Recommendation Report for Planning Permission for Works or Extension to a Dwelling

REF NO: LU/255/19/HH

LOCATION: 33 Potters Mead
Littlehampton
BN17 7HY

PROPOSAL: Construction of two storey side extension and associated works

drawing
Floor Plans and Roof Plan
As Proposed

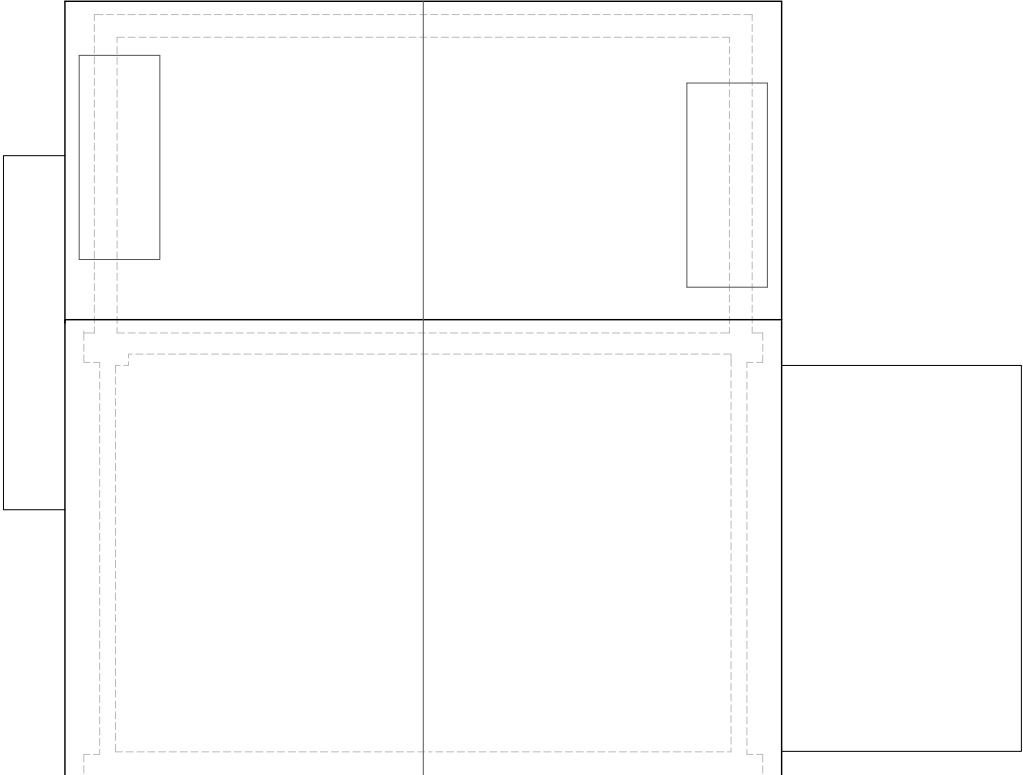
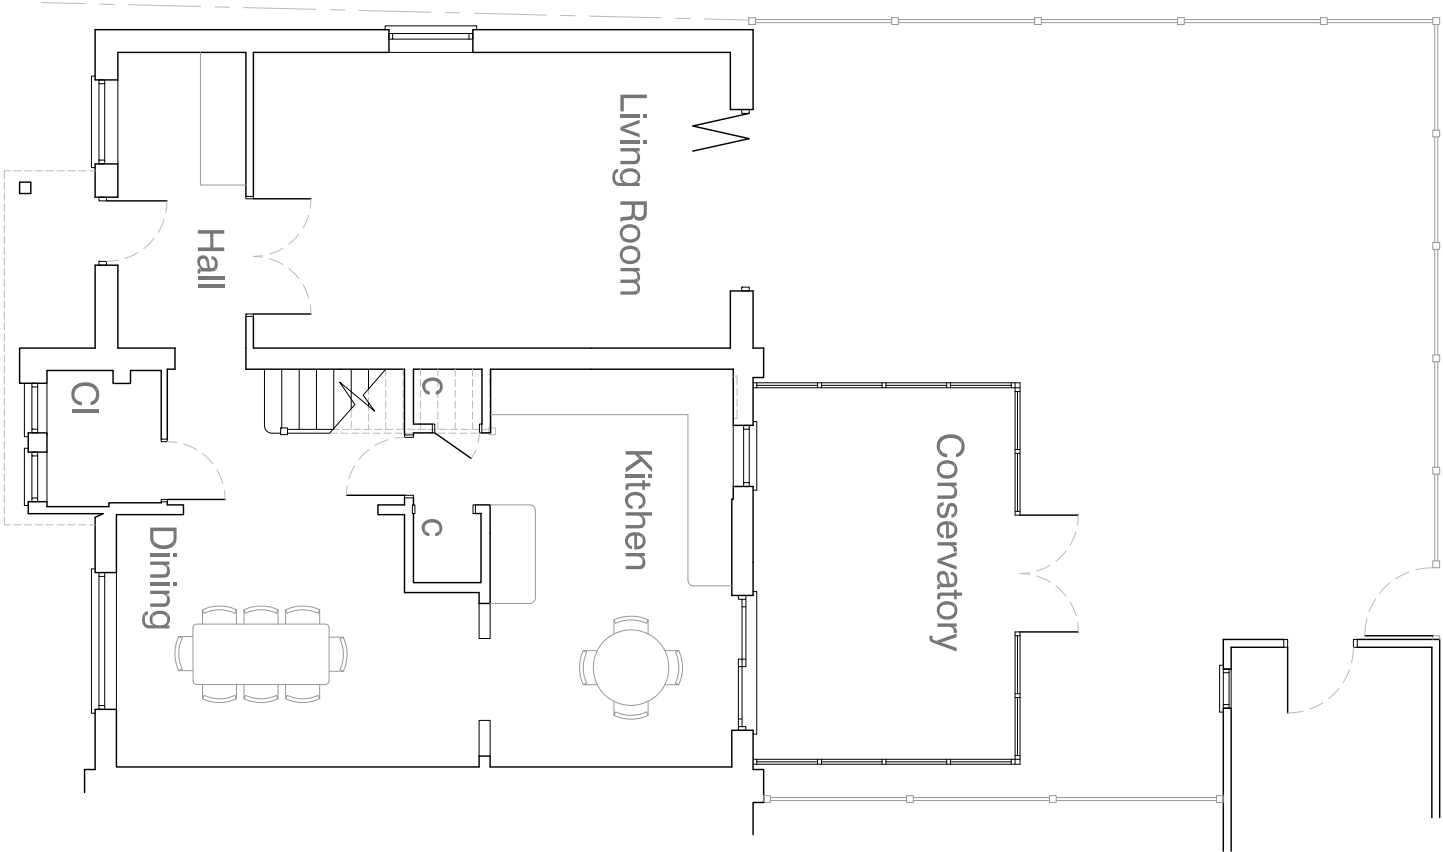
This is exemplified by the block of flats to the East being 5.9m from the street scene, 100 Courtwick Road being 6m from the street scene, and similar distances being found at 1 Wheatcroft, 39 White Acre. The proposal will jar with this character/appearance in that the extension would be a minimum distance of 0.16m from the Eastern boundary of the highway. This area will be enclosed and thereby appear as an incongruous and alien feature within the locality and when seen within Potters Mead.

In an area of reasonably uniform dwellings, with similar front porches, the provision for a wider porch with an alternative roof design would add to the cumbersome resultant appearance of the property within the immediate locality.

Furthermore, the maximum height of the extension is only 0.5m lower than the host dwelling, and is approximately 4.4m wide, a width comparable to that of the existing dwelling. Such a non integrated design unduly harms the appearance of the host dwelling.

project	33 Potters Mead		
	Littlehampton		
	West Sussex		
drawing	Elevations and Typical Cross Section		
As Proposed			
-

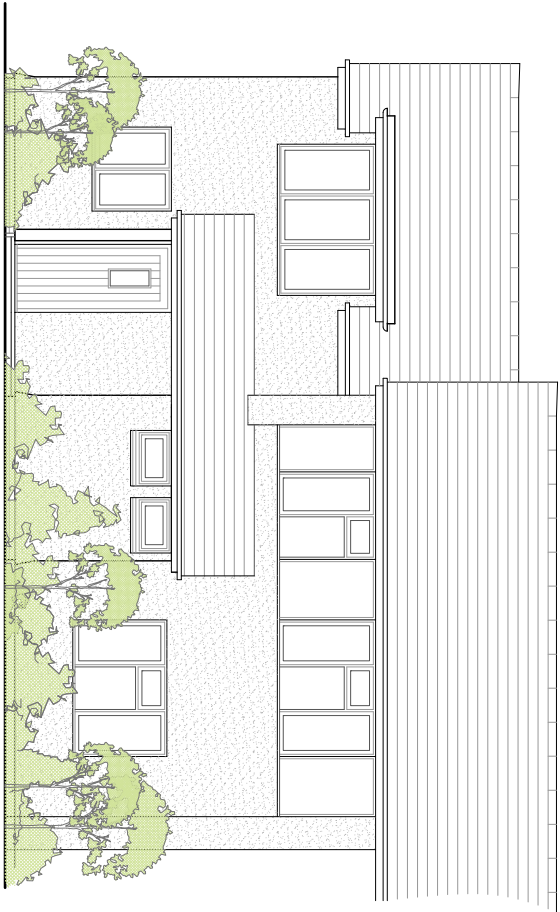
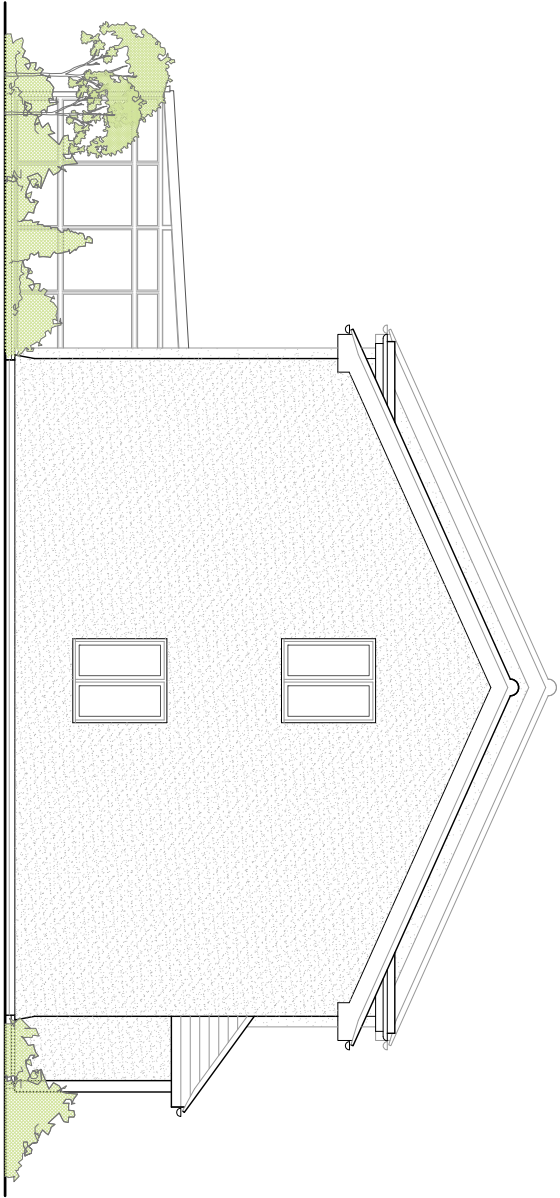
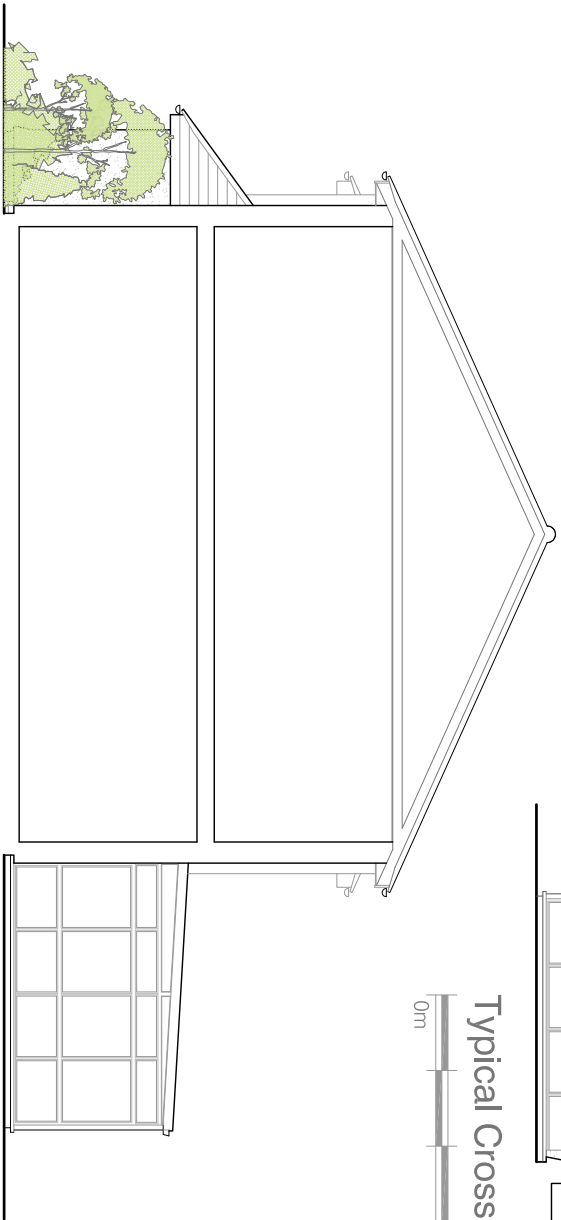
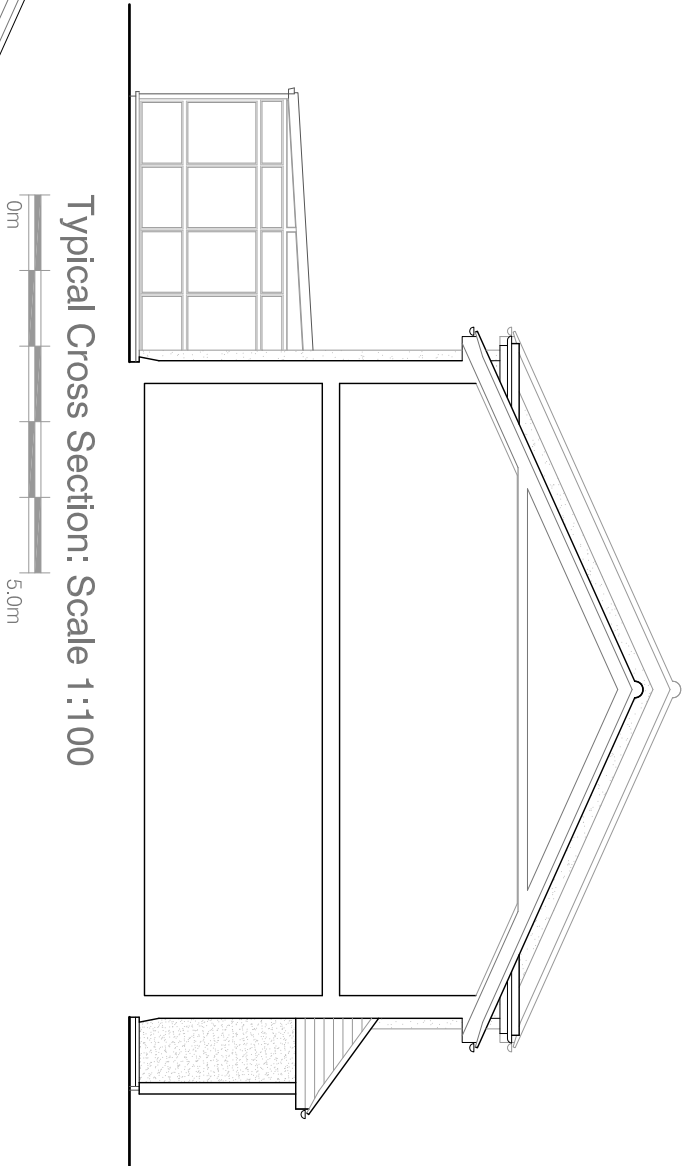
As a result of its open and prominent location, the bulk and scale of the proposed development will not appear subservient to, or well integrated with the host dwelling or the wider area in conflict with policies D SP1, D DM1 (1) & (14) and D DM4 (a) & (e) of the Arun Local Plan.
